# CITY OF ALBUQUERQUE

**Re: Presbyterian Systems Office Drainage Management Plan and Grading and Drainage Plan**

**Engineer's Stamp dated 6-13-12 (B17/D003)**

GRADING &
DRAINAGE PLAN

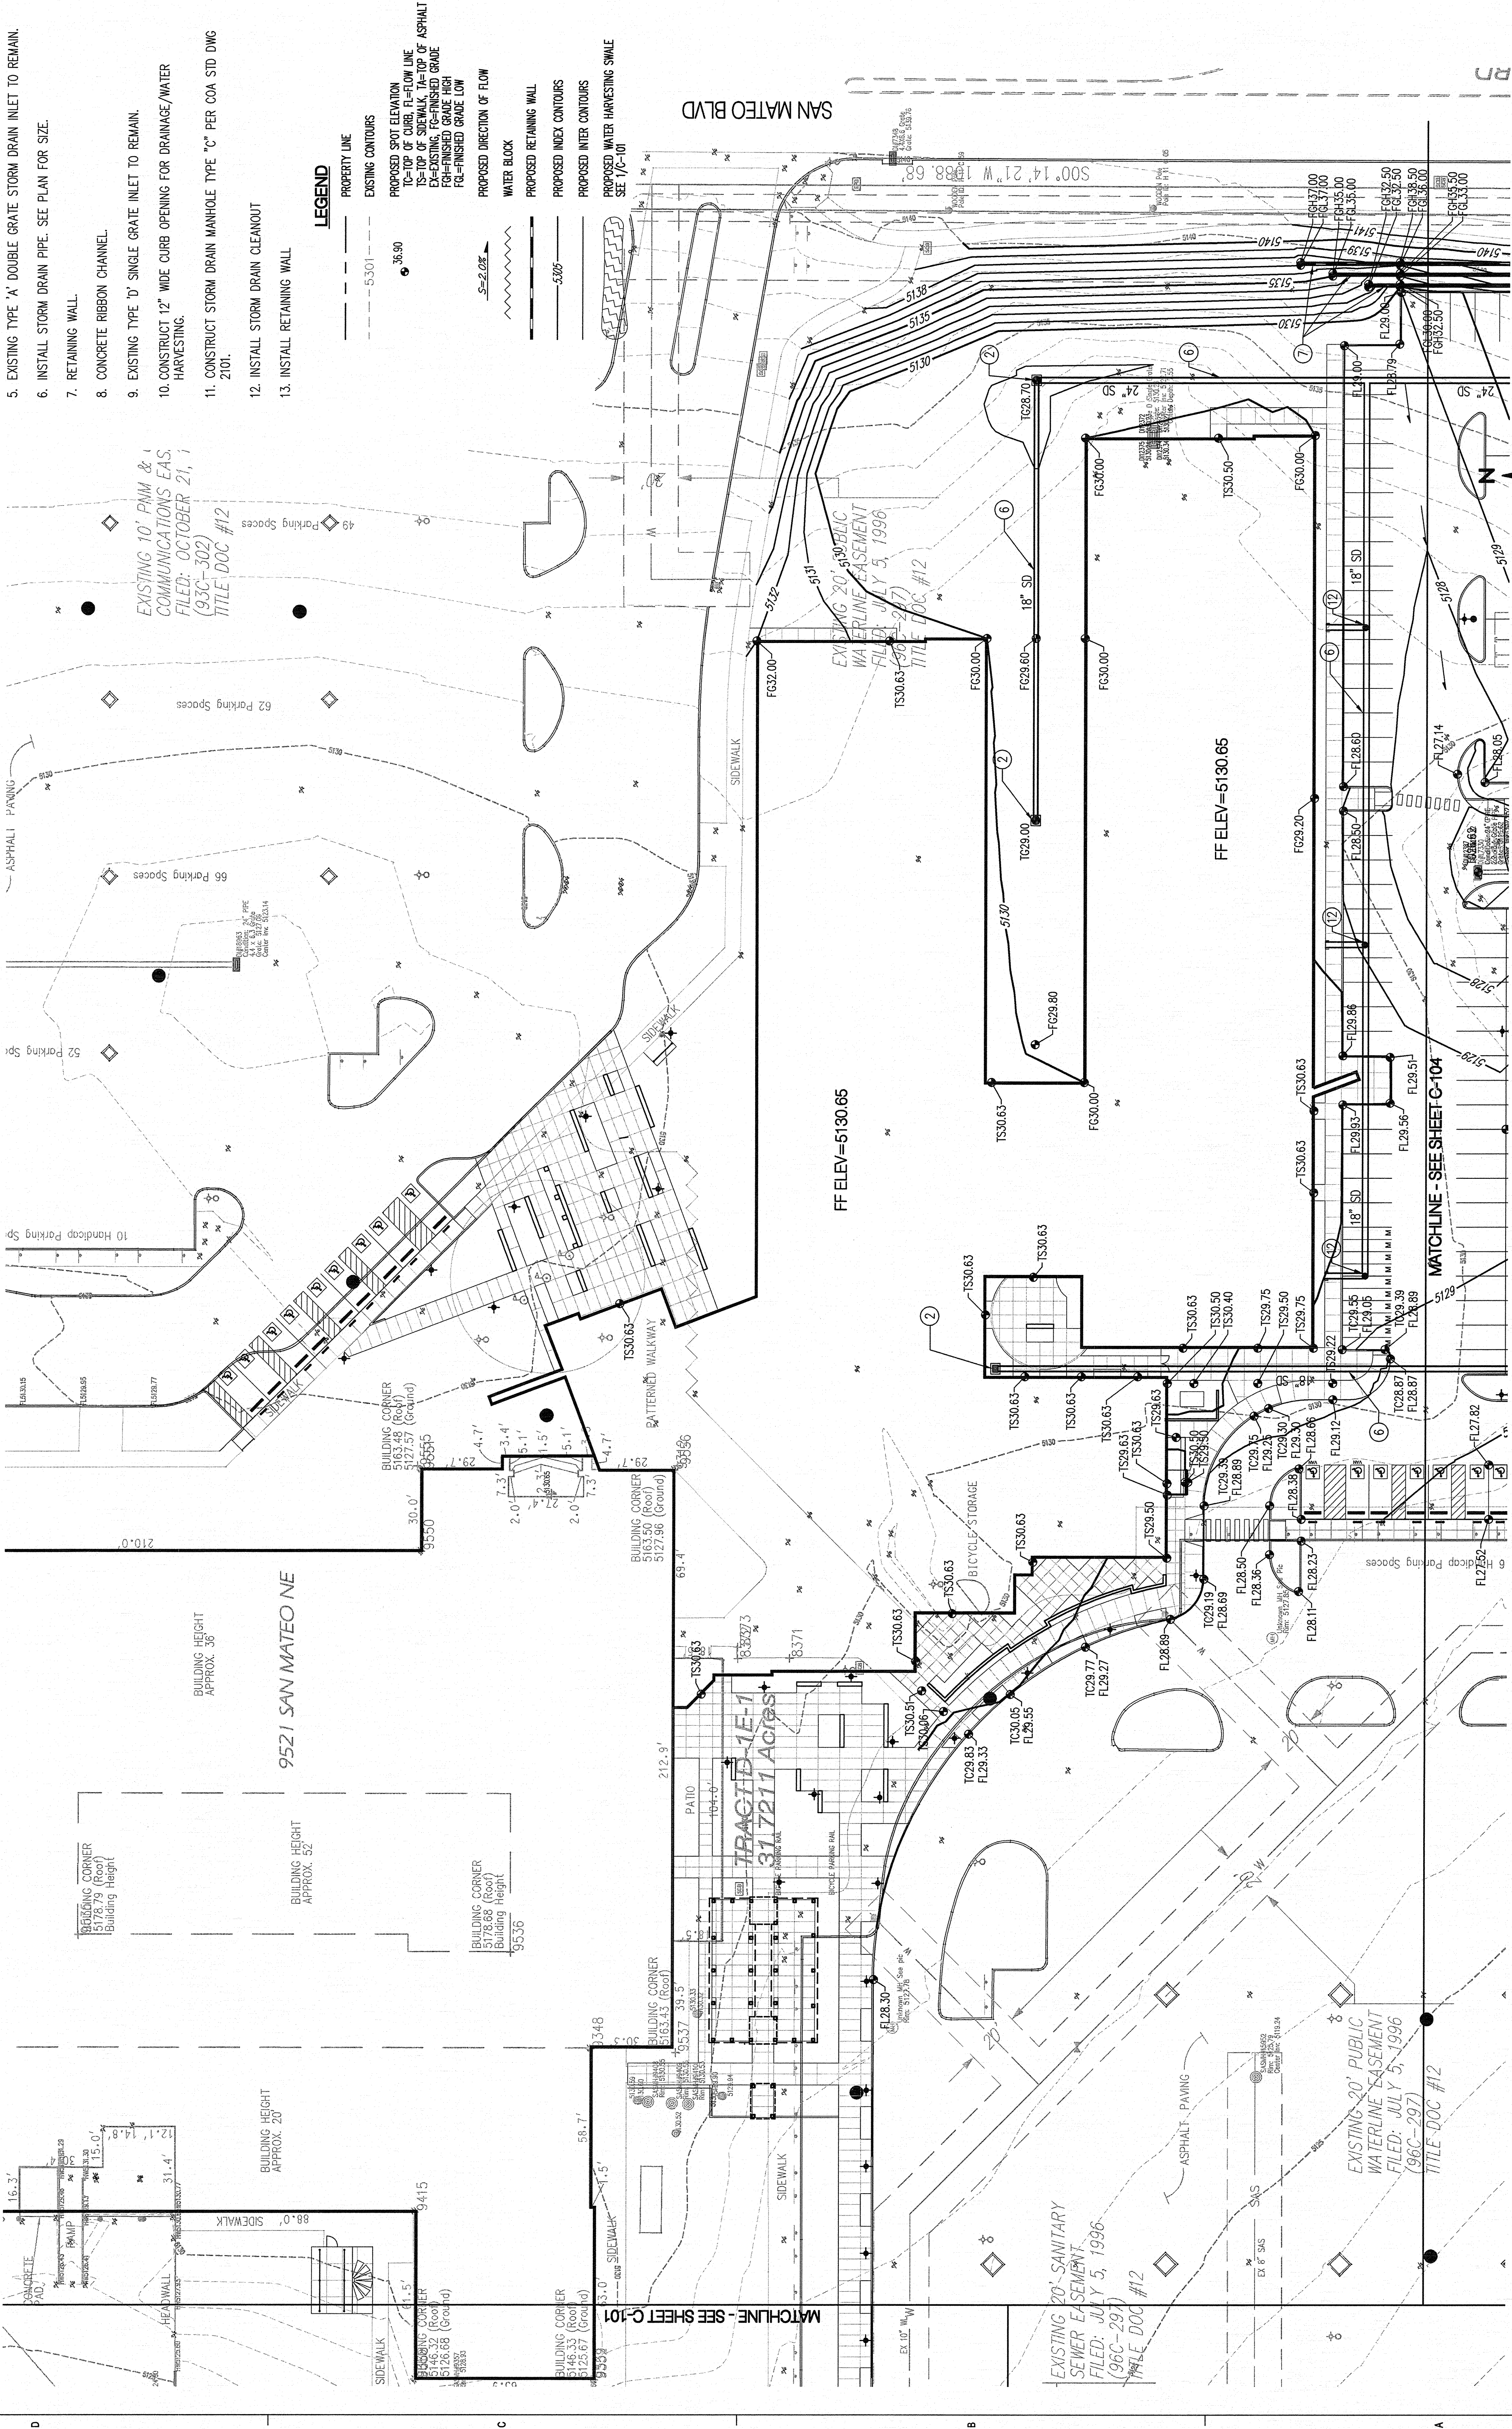
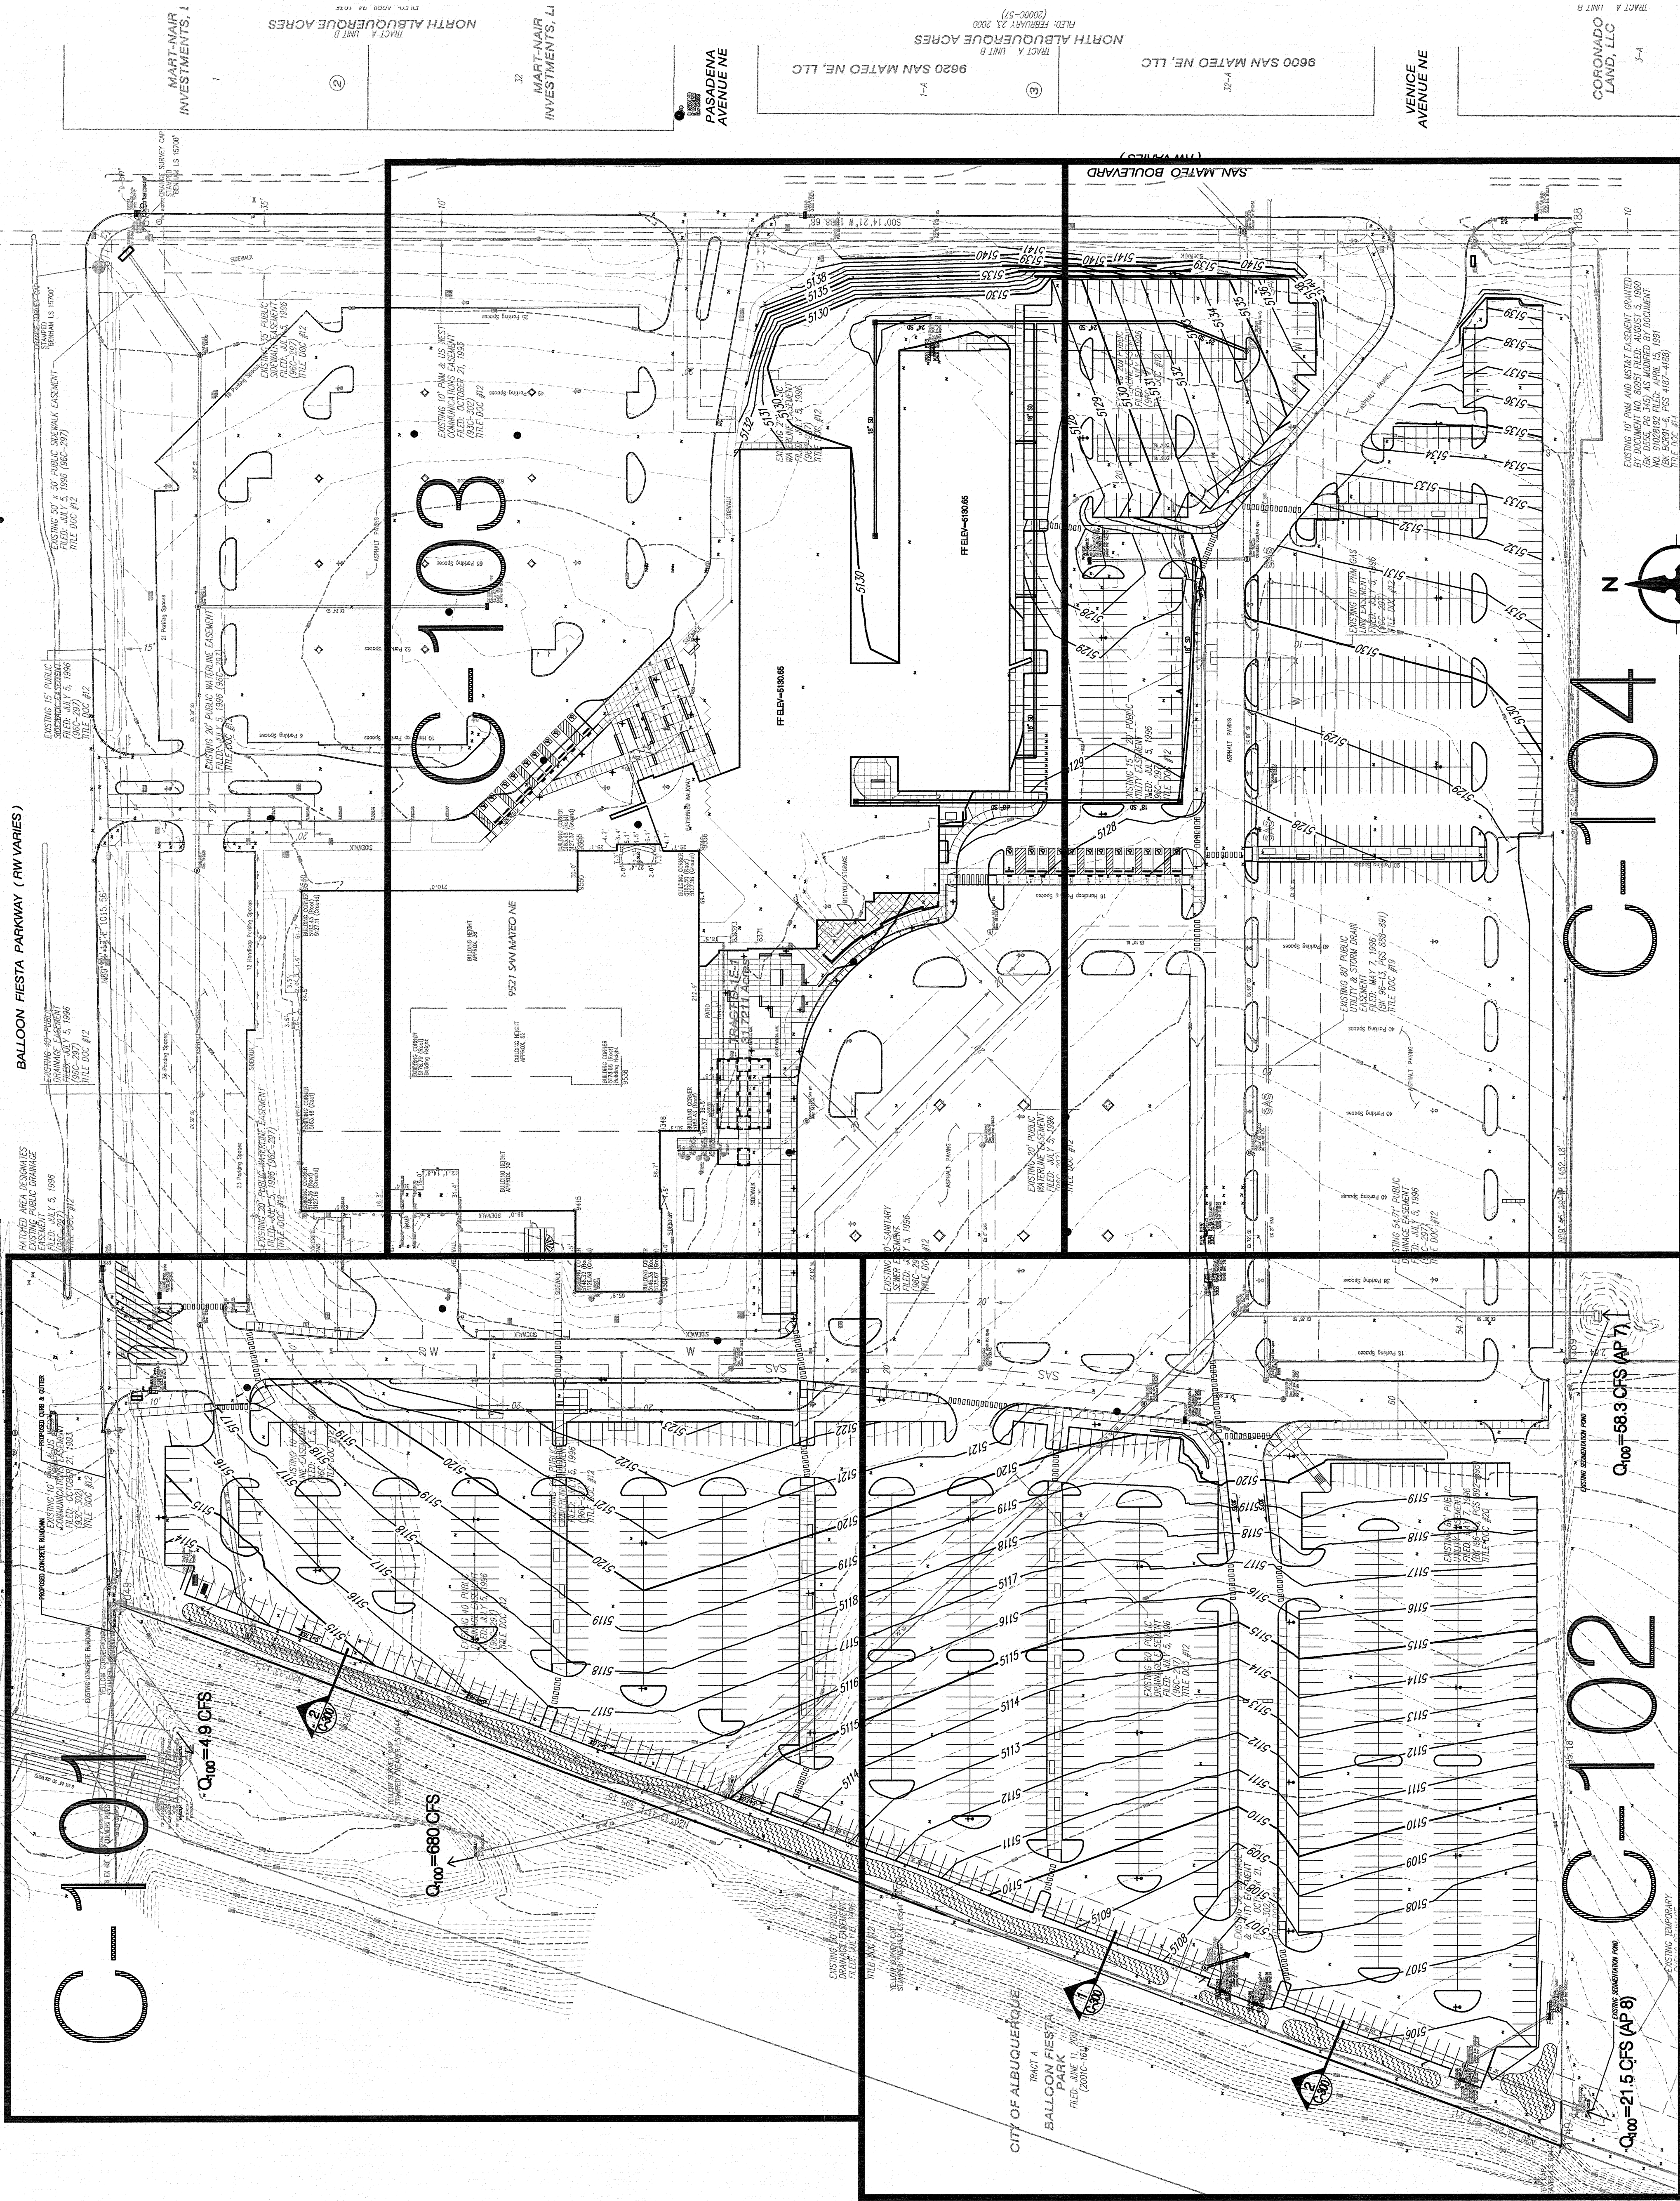
- Since the Grading and Drainage Plan is included in the Site Plan submittal to DRB, include the items listed under Drainage Management Plan.
- Show the proposed curb and gutter and drainage rundown with flows.
- Show that the west side of the water harvesting area is higher than top of curb in Detail 1. In case this area spills, it should spill to the east.
- Provide existing grades along the western property line that adequately depicts the slope.
- Comments provided on the grading and drainage plan were conceptual only. Additional comments may be provided when the plan is submitted for Building Permit approval
